PROJECT
FALCON STORAGE PARCEL
PART W 1/2 SEC. 1, T.13S., R.65W., 6TH P.M.
EL PASO COUNTY

SHT. NAME
GRADING AND EROSION CONTROL PLAN

PCD PROJECT NO: PPR2232 & MS232

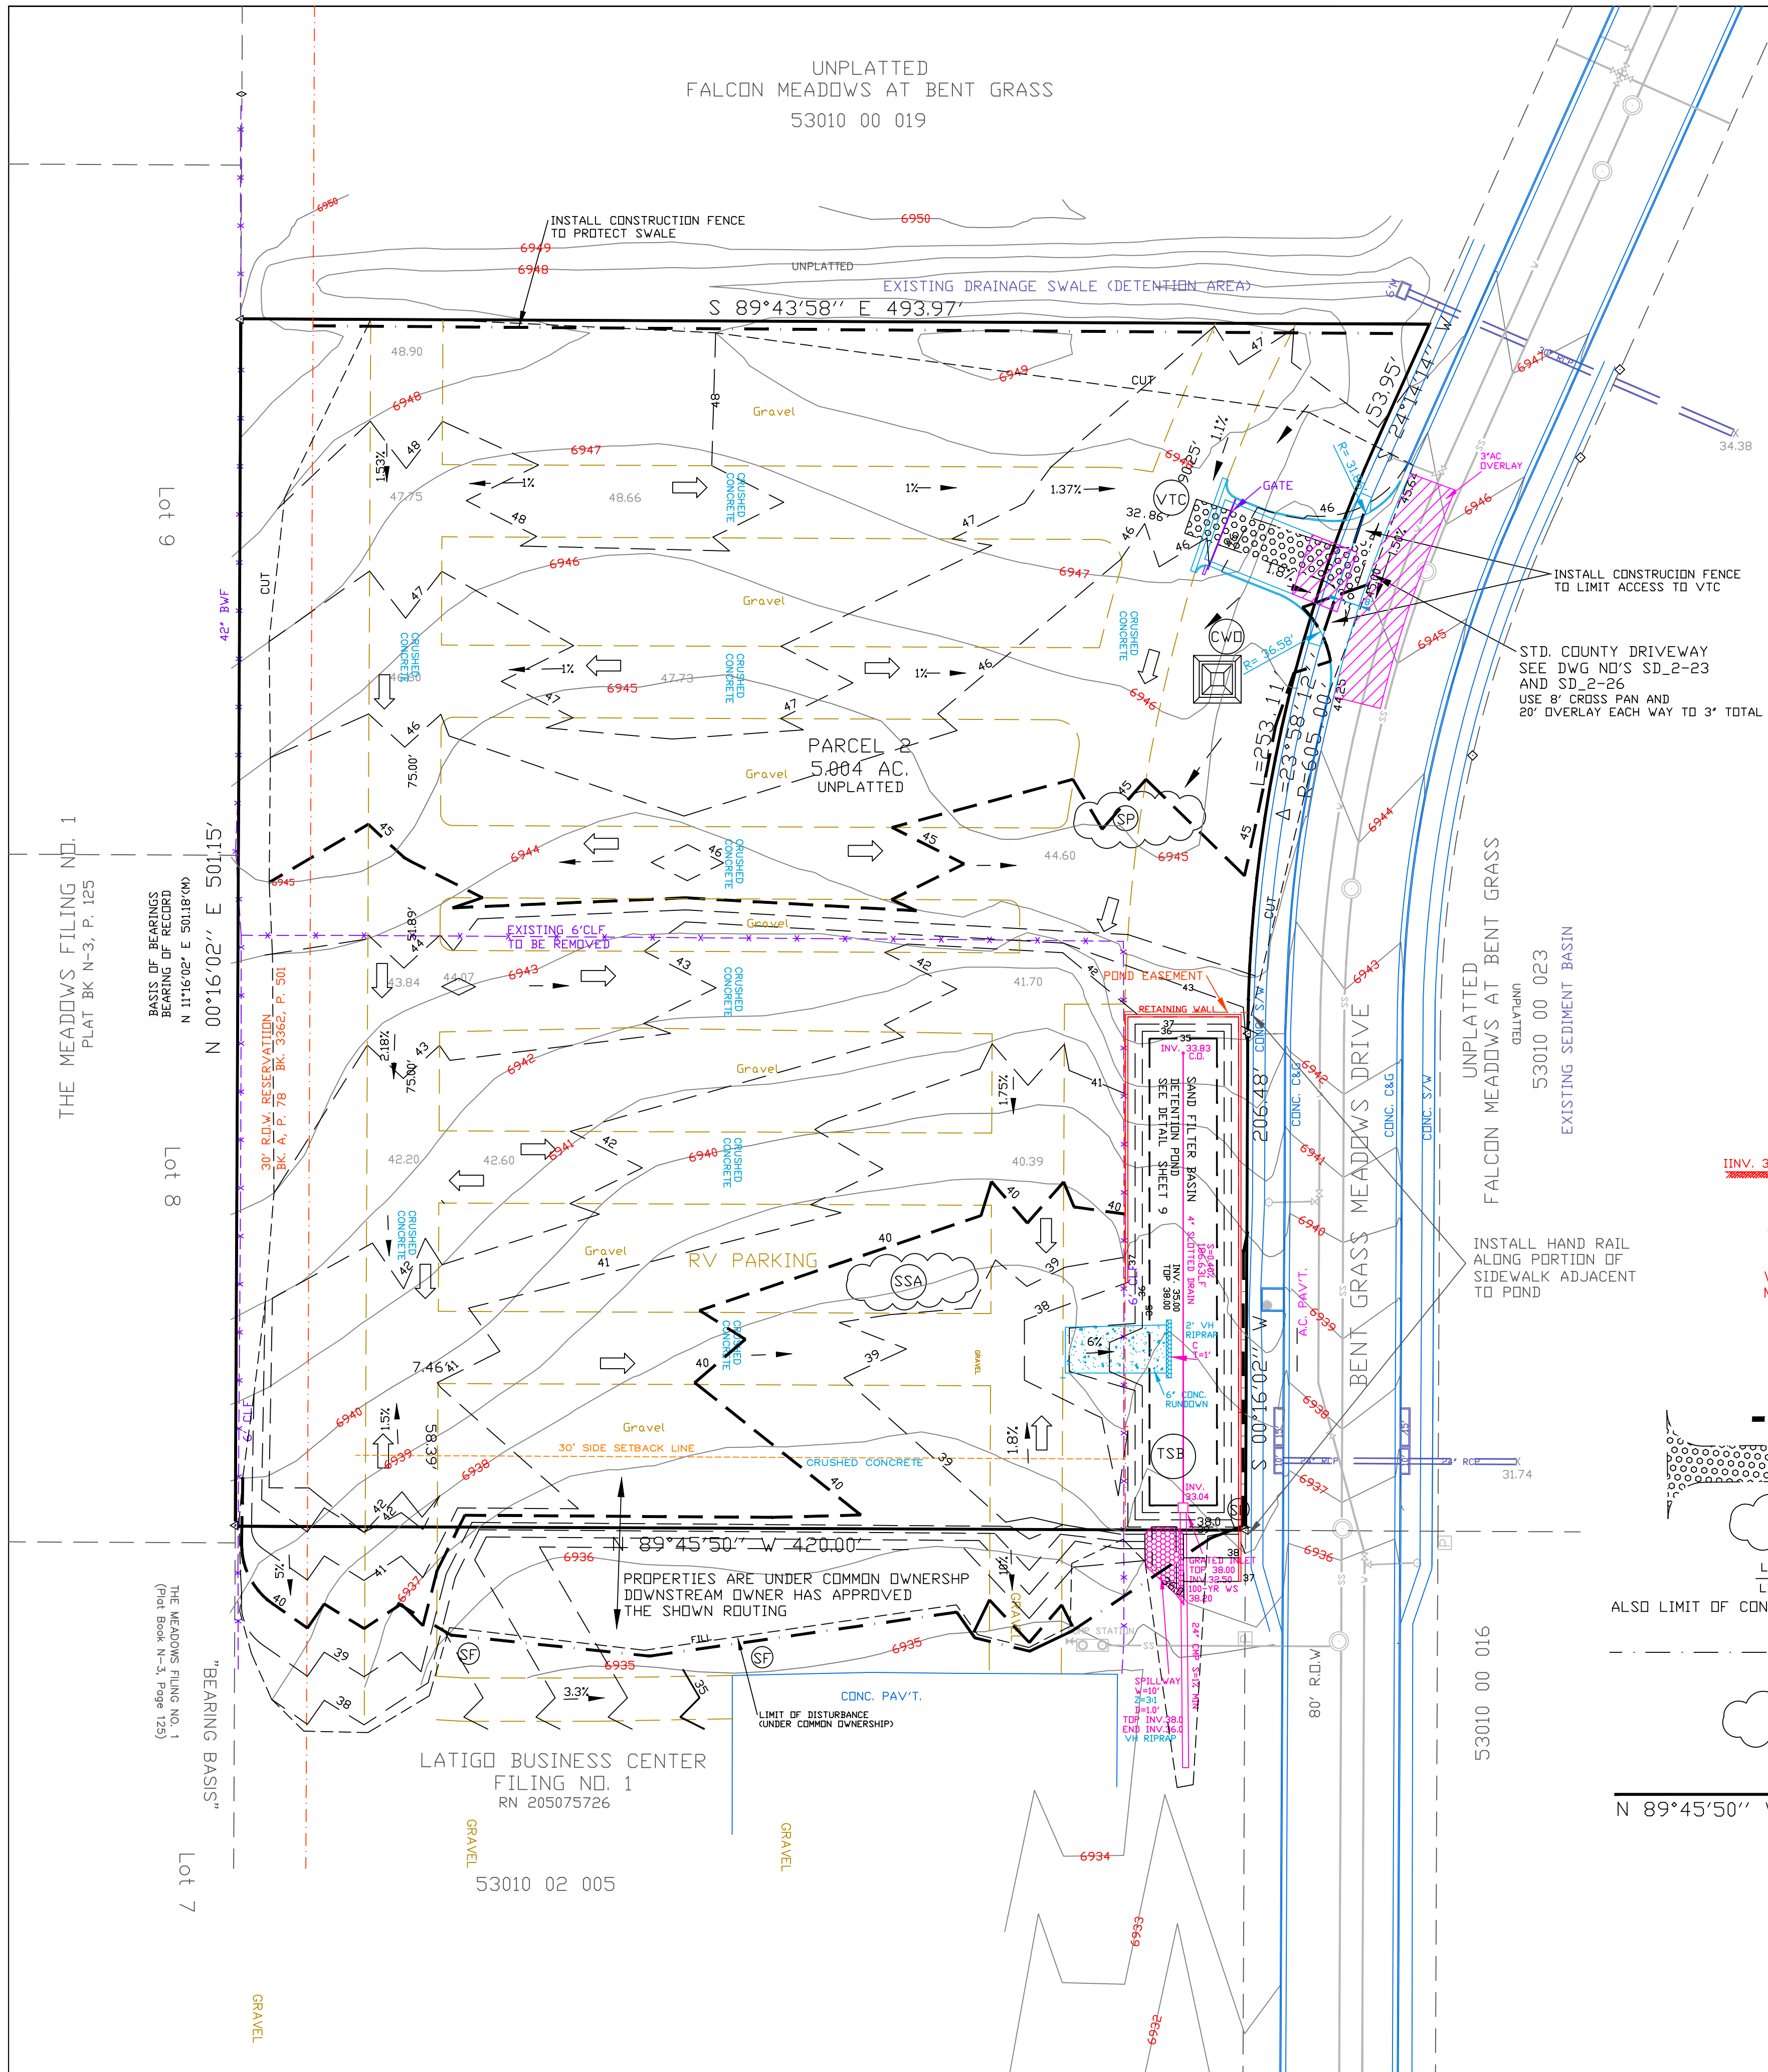
show existing detention basin where flows are being routed to an existing detention pond. SWMP states: This project outfalls to an existing detention pond, Falcon Meadows on the south side of Woodmen Road, owned and operated by another entity. unresolved.

to match existing grade?

review 1: Please label and provide detail of the proposed PED ramps on each side of the driveway. Identify the cross slope at the pedestrian path at the driveway (2%max)
Review 2: Please label the proposed PED ramps and identify County detail SD_2-41

Assign a name/number to all PBMPs and then update all submitted text and drawings accordingly with consistent labeling throughout (example: "Pond A" or "Pond 1"). unresolved.

Final stabilization needs to be shown on figure. Consider creating a separate sheet to show all areas for proposed asphalt, proposed concrete, and proposed seeding/mulching. Unresolved.

add TW and BW spot elevations

Identify that this shall be onsite and not within County ROW

detail elevation is 36

outlet protection detail.
The invert of the outlet pipe is 32.50, the pipe will not daylight at this location, revise accordingly.

provide inlet protection unresolved

line type does not match legend unresolved.
